Re-alignment of Gas Main Consent SSD_5093 (Mod 1)

Response to Submissions

September 2015

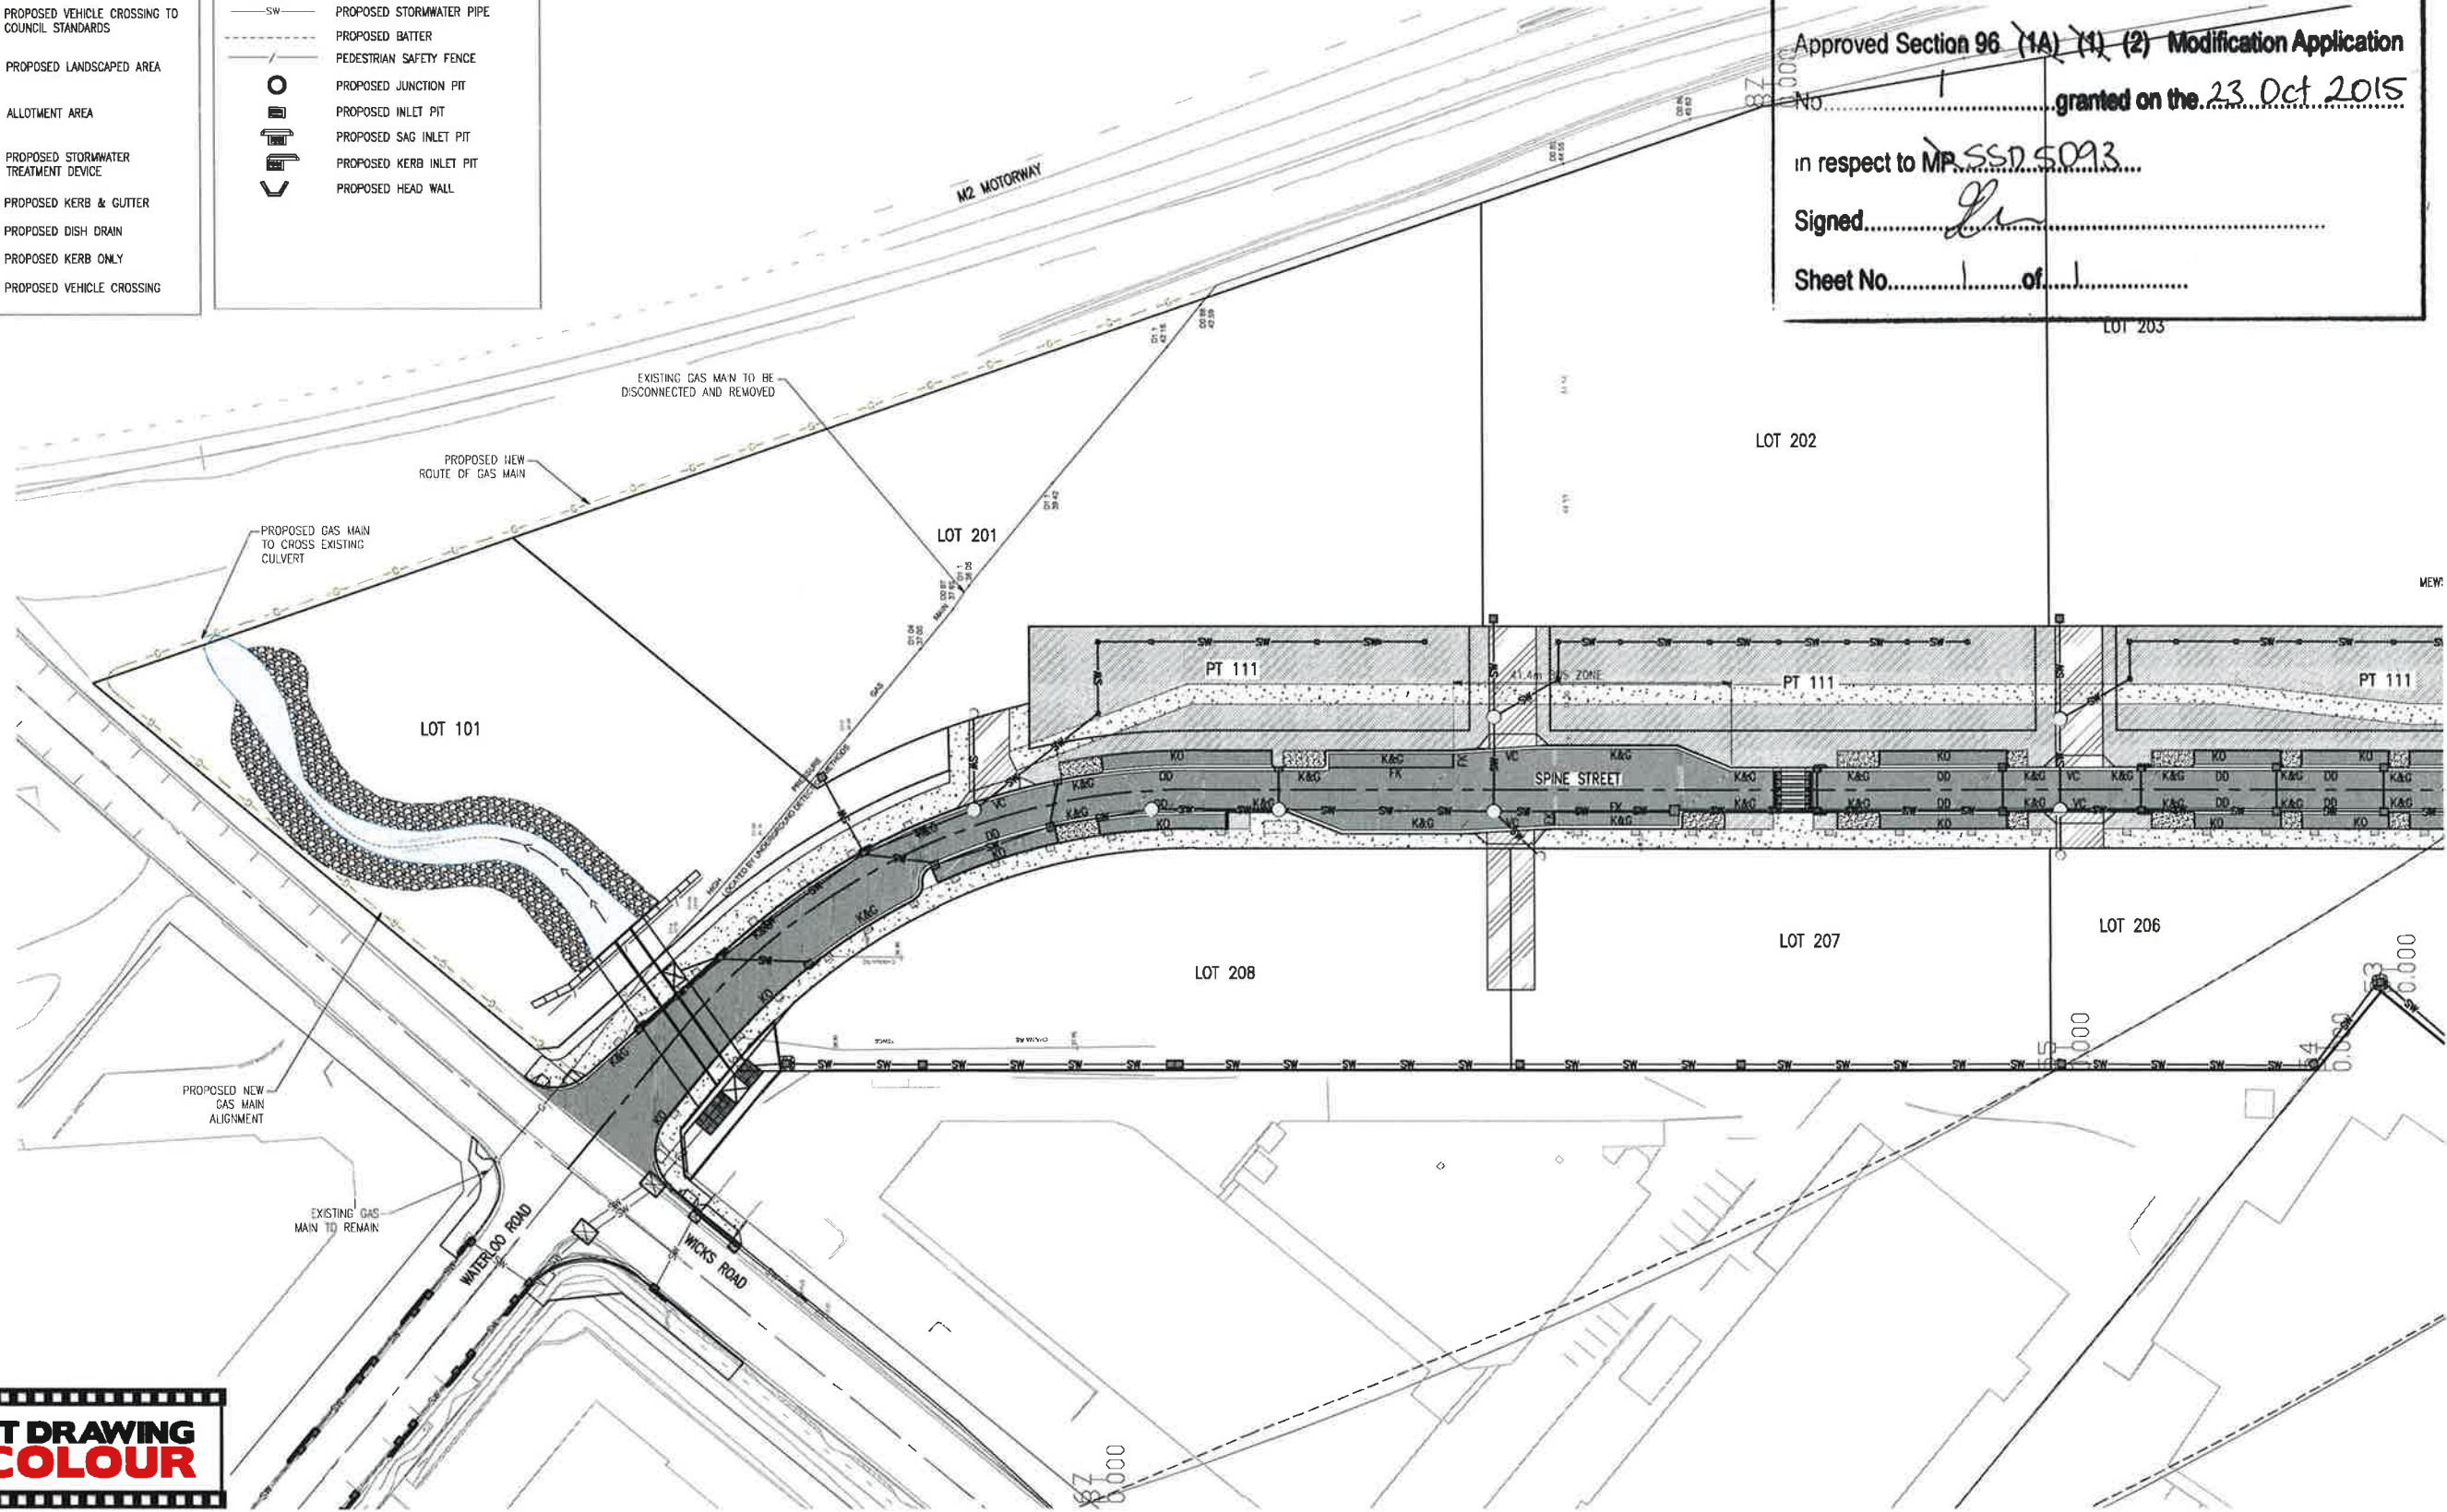
An amendment to the proposed alignment of the gas main is proposed in response to issues raised by Ausgrid related to the potential impact of the proposed gas main on existing 132,000v cables in the Wicks Road reserve.

AUSGRID	
Issue raised	Response
<p>Ausgrid have identified potential impacts or interfaces with exiting two 132,000 volt cables that in the vicinity of the proposed gas main.</p> <p>Ausgrid advise that it will provide consent to the development provided that the following conditions are met by the Proponent:</p> <ul style="list-style-type: none">i. Confirmation of the location and status of existing Ausgrid infrastructure;ii. Confirmation of any infrastructure which requires relocation;iii. Provision of a design taking into consideration electric and magnetic fields (EMF), stray currents associated with Ausgrid's	<p>Potholing, service scanning, survey and Dial-Before-You-Dig (DBYD) information have confirmed the presence of the existing Ausgrid cables within the Wicks Road reserve.</p> <p>UGNSW has considered the potential impact of the proposed alignment of the gas main within the Wicks Road reserve on existing Ausgrid infrastructure.</p> <p>An amended plan (Drawing number C-0-9-20 "Plan of Proposed New Route of Gas Main to Accompany an Application by UNSW to Amend Consent SSD_5093") showing the relocated gas main is provided to replace the Plan submitted with the modification application. The amended plan proposes to maintain the alignment of the approved gas main along Wicks Road frontage as</p>

ISSUE	RESPONSE
John McCain and Diane Michel	
<ul style="list-style-type: none"> Seeking clarification on the precise location and alignment of the proposed gas main in relation to the culvert in the M2 Corridor. 	The location of the proposed gas main is shown on the Plan at Appendix A . The gas main will be located within a 1.2 metre deep trench approximately at the centre of a 3 metre width corridor offset from the M2 Motorway Corridor Lands boundary.
<ul style="list-style-type: none"> Confirmation sought on the on-going management of the corridor. 	The M2 Motorway Corridor Lands is managed by the motorway operator, under the terms of a lease from the RMS. UGNSW will be responsible for the rehabilitation of the gas main corridor, in accordance with the recommendations of the Flora and Fauna Assessment prepared by ELA, consistent with the condition of consent invited in this modification application. Responsibility for on-going management of the M2 Corridor Lands rests with the motorway operator.

infrastructure;	approved in Consent SSD_5093.
iv. Agreement on appropriate work methodologies and risk mitigation actions for works in the vicinity of Ausgrid's infrastructure; and	Maintaining the approved alignment of the gas main within the boundary of the site, along the Wicks Road frontage will avoid any additional impact on existing utilities and services within the Wicks Road reserve. The conditions suggested by Ausgrid are therefore considered unnecessary.
v. Provision of evidence supporting the development has no impact to the safe operation and maintenance of Ausgrid's infrastructure.

The response to the submissions and provision of additional information has resulted in an amendment to the proposed development, as shown in **Figure 1**. The new alignment of the gas main proposes to retain the approved alignment within the Lachlan's Line site along the Wicks Road frontage.

“Plan of proposed new route of gas main to accompany an application by UGNSW to amend consent SSD_5093” (Ref: Drawing No. 13656B C-0-9-20 Rev. 4) prepared by Robert Bird Group
